**Accent Housing Ltd**

**Plane Street  
Huddersfield**

**Stage 1 Road Safety Audit**

Report Ref:	11294/AND/001/01	June 2020	
Author:	Adam Darwin		
Checked & Approved:	Simon Burkinshaw	Date:	24 <sup>th</sup> June 2020

Drawing Reference: Stage 1 RSA Marked up Plan

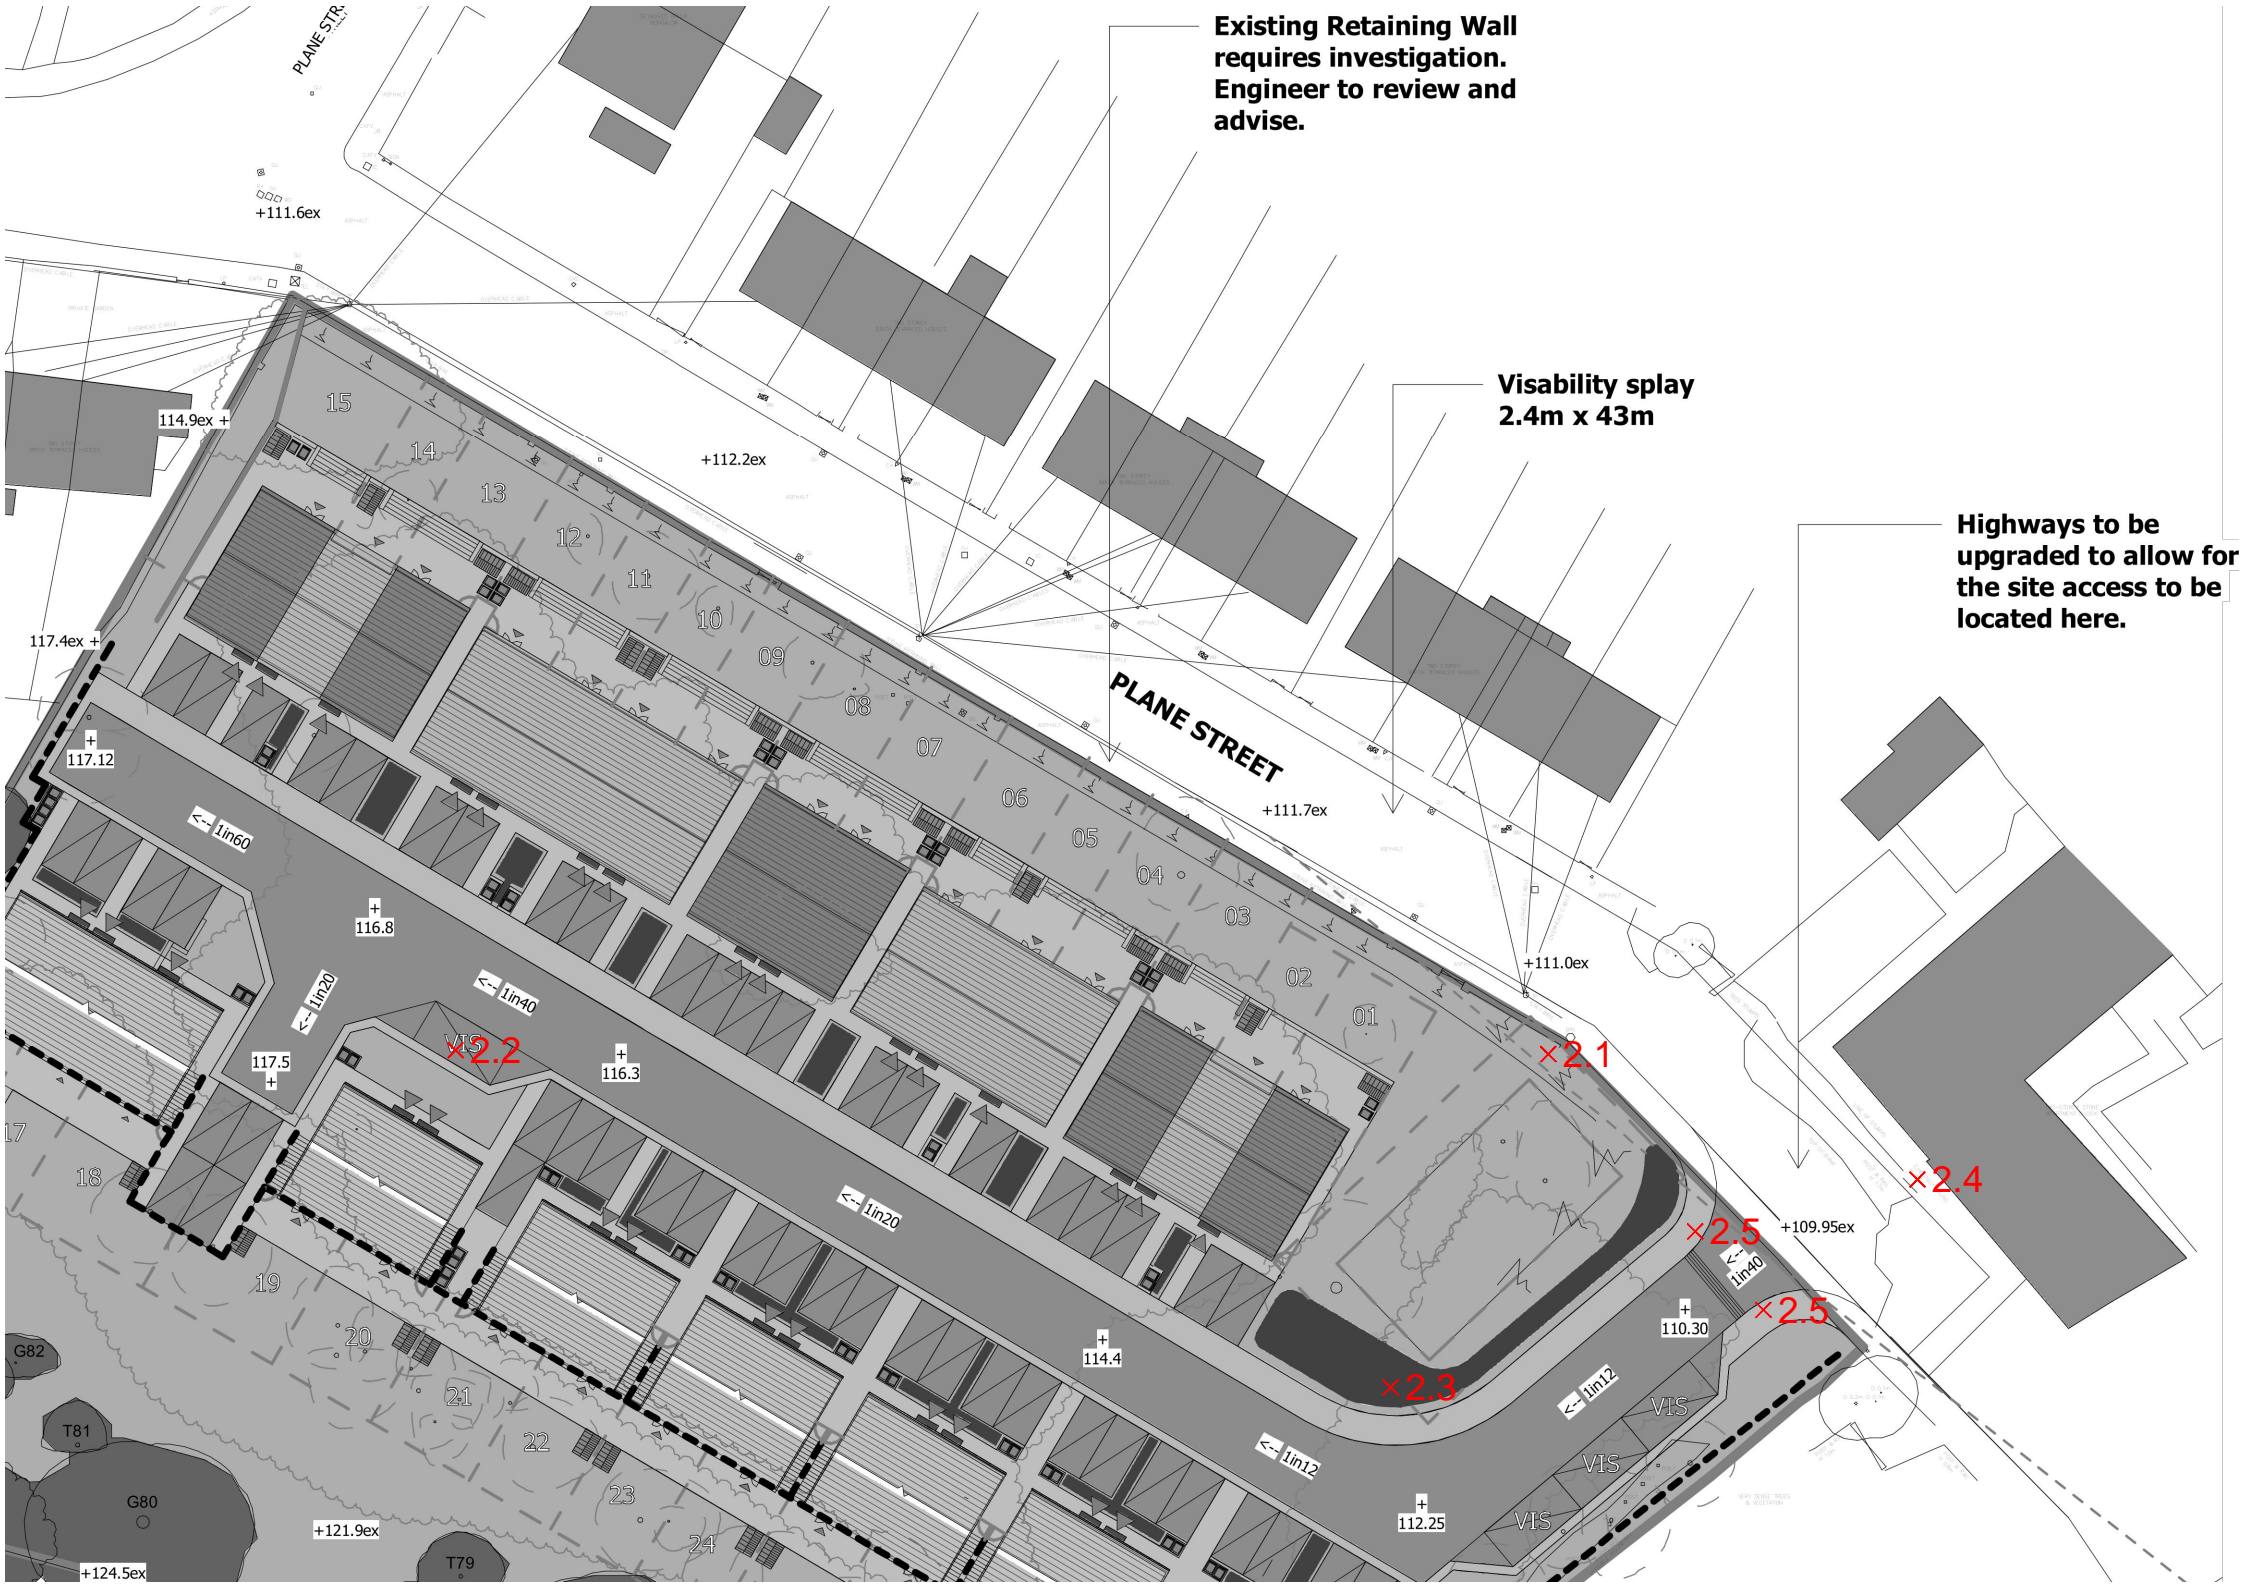
**Summary:** The 2.4x43m visibility splay to the west of the site access is shown passing over the existing site boundary wall. Whilst it is assumed that that the wall will be set back behind the proposed visibility splay, this is not shown on the plans and the ability to do so may be affected by the proposed attenuation tank and easement. Should the wall not be set back, this may restrict visibility at the site access below acceptable minimum levels, which could result in turning type collisions at the junction.

**Recommendation:** It is recommended that the site access visibility splays are kept clear of any significant vertical obstructions, including walls and larger street furniture (e.g. the existing waste bin).

**Summary:** It is proposed to extend Plane Street to the east to allow the new site access to be formed on to it. However, there will be a significant level drop on the north side of this extended section of Plane Street opposite the site access, which would be hazardous to any errant road user. Should an eastbound vehicle travelling towards the site access lose control and leave the carriageway on the north side, there is a risk of a severe incident occurring due to the significant level drop.

**Recommendation:** It is recommended that restraint measures are incorporated on the northeast end of Plane Street to protect all road users from this hazard.

Existing Retaining Wall  
requires investigation.  
Engineer to review and  
advise.

Highways to be  
upgraded to allow for  
the site access to be  
located here.

11293-005 – Forward Visibility on Internal Layout

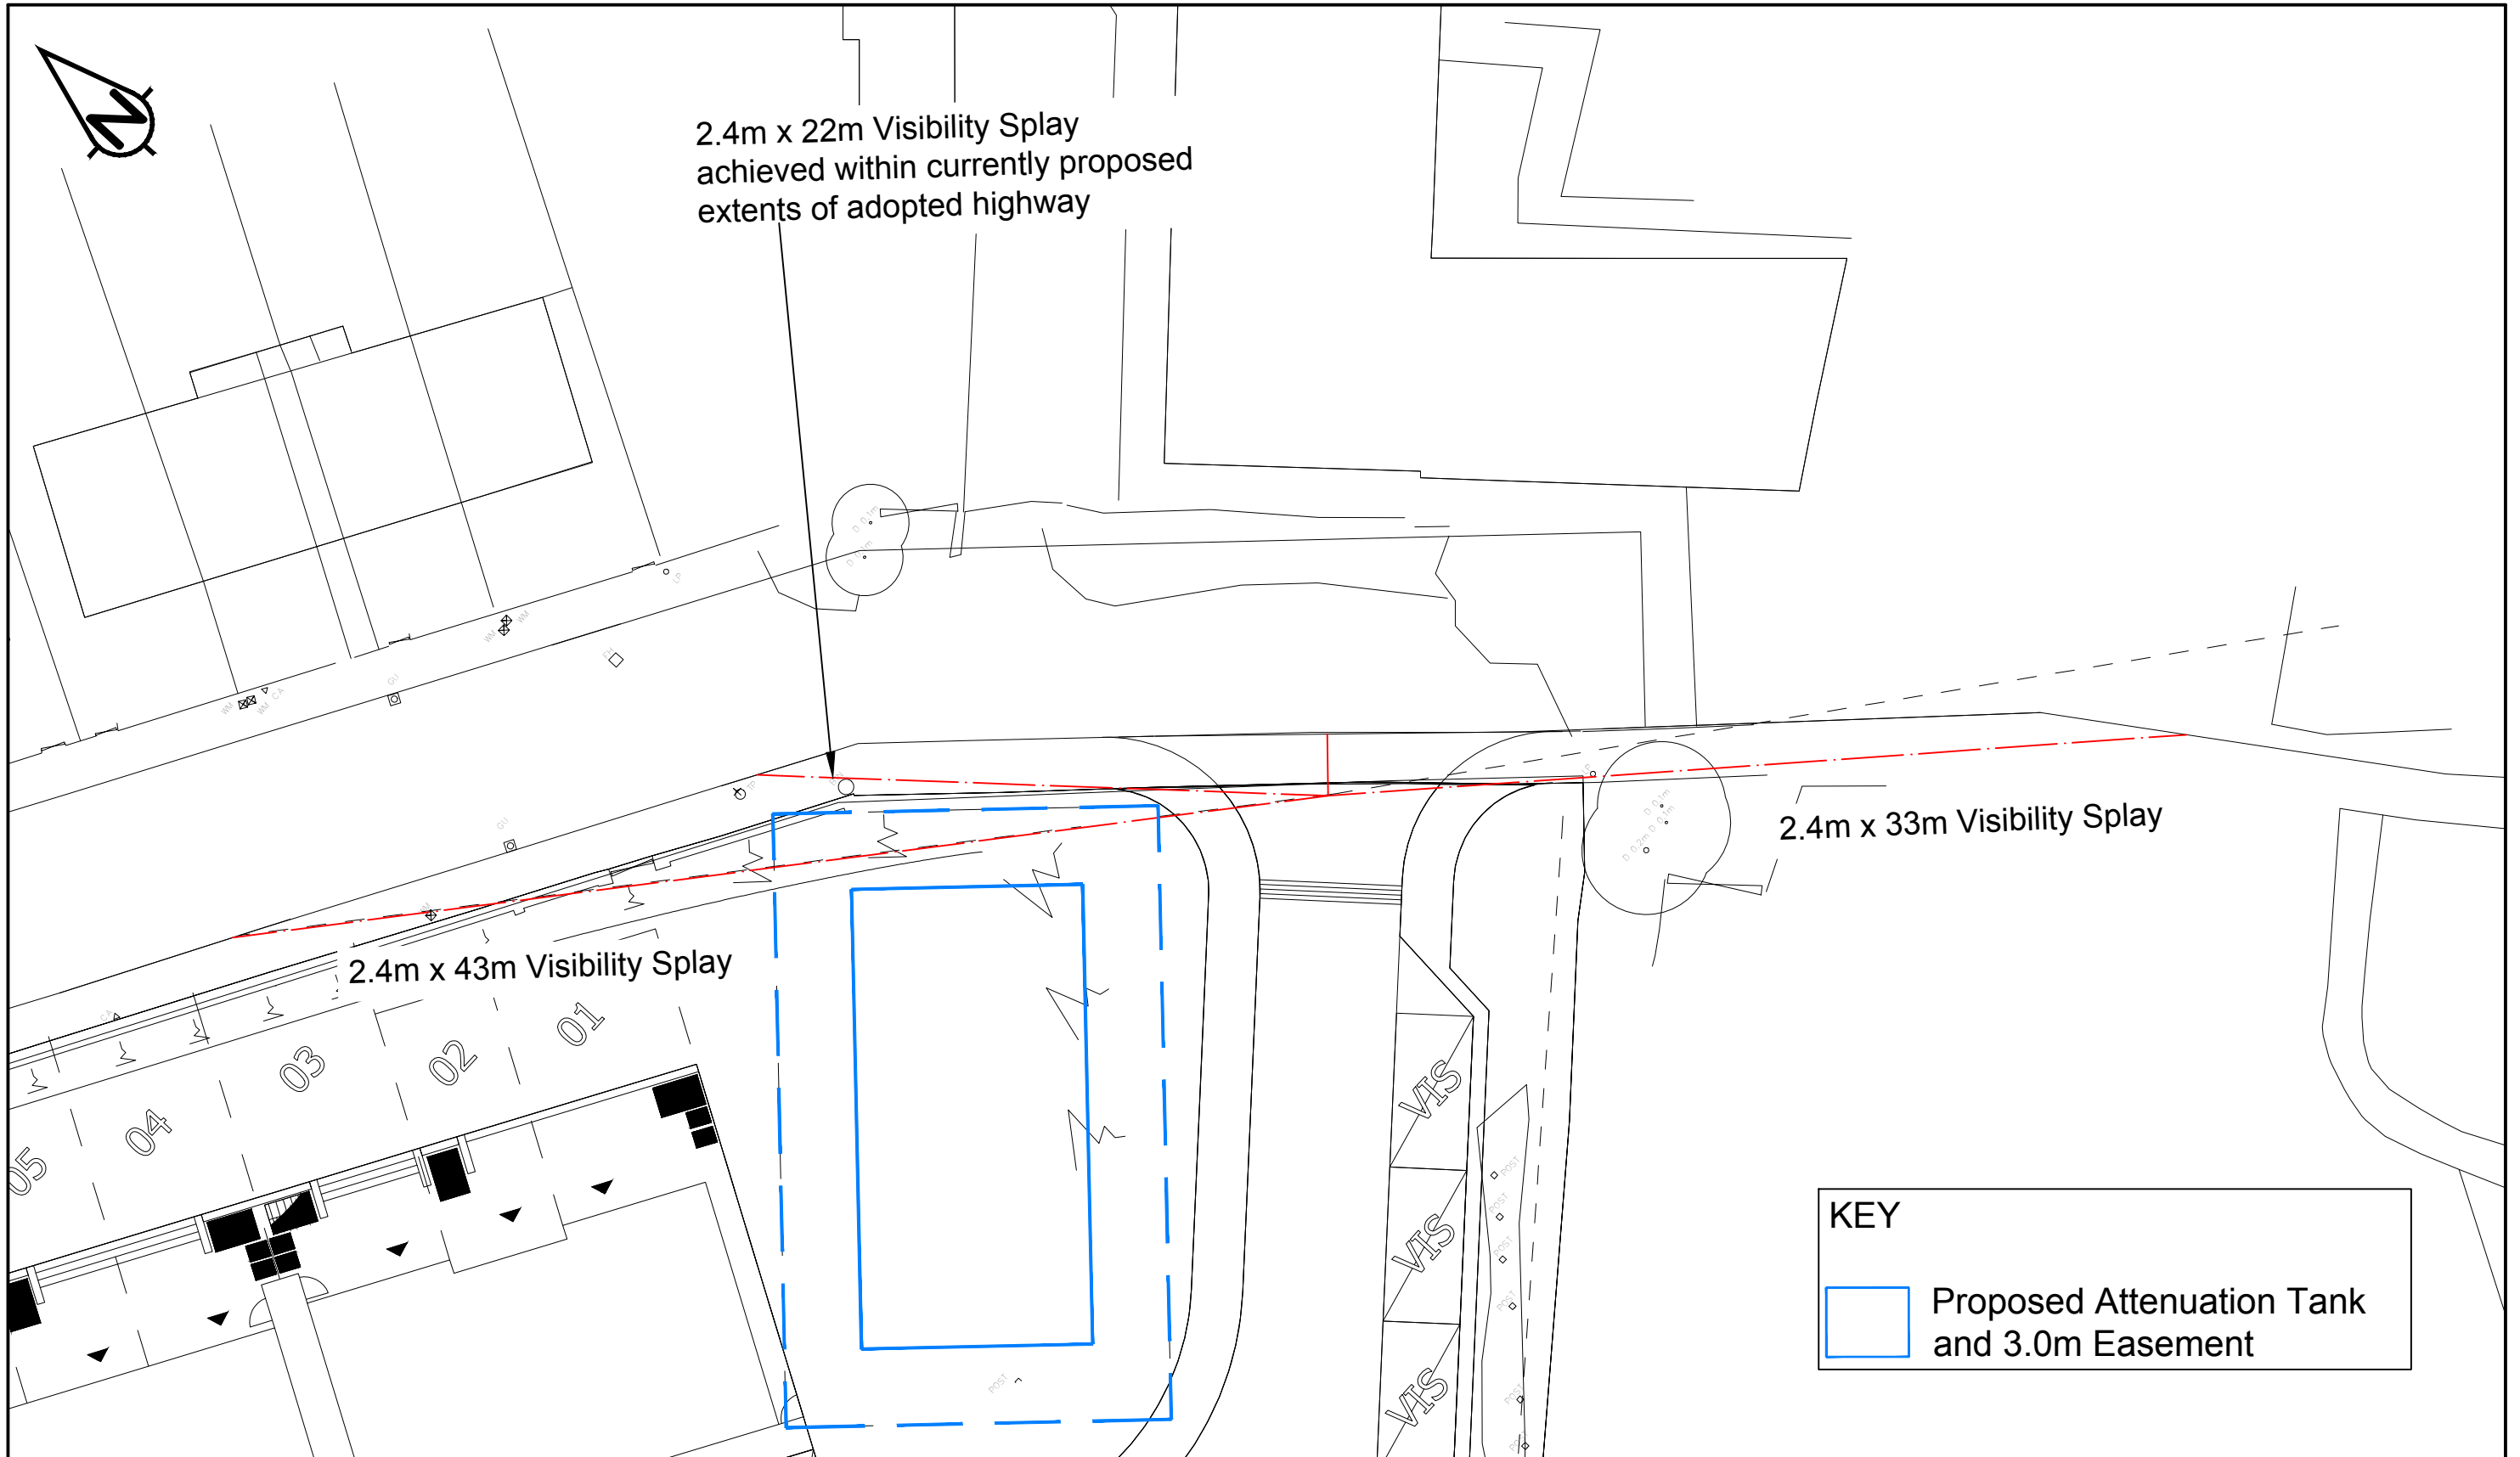
**Summary:** There is a relatively tight bend on the site access road, where it would not be possible for a refuse vehicle to pass a car. Whilst this is not necessarily a significant issue on its own due to the low traffic flows that is expected along the road, it is unclear if there will be adequate forward visibility around the bend to allow drivers to give-way before they meet an oncoming vehicle at the bend. As such, this could lead to head on collisions at the bend.

**Recommendation:** It is recommended that adequate forward visibility is provided at the bend that allows drivers to observe an oncoming vehicle; and then wait as necessary before the bend to allow the oncoming vehicle to pass.

Swept Path Analysis of
 refuse vehicle turning
 at proposed site access

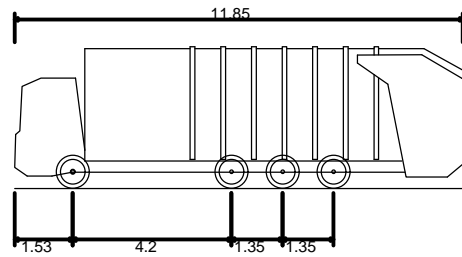
It is also recommended that the swept path analysis is undertaken to confirm that refuse vehicles can turn at the extended end of Plane Street next to the site access junction, in the event that the access road still becomes blocked and this area is required to allow a refuse vehicle to turn without reversing all the way back to Malvern Rise.
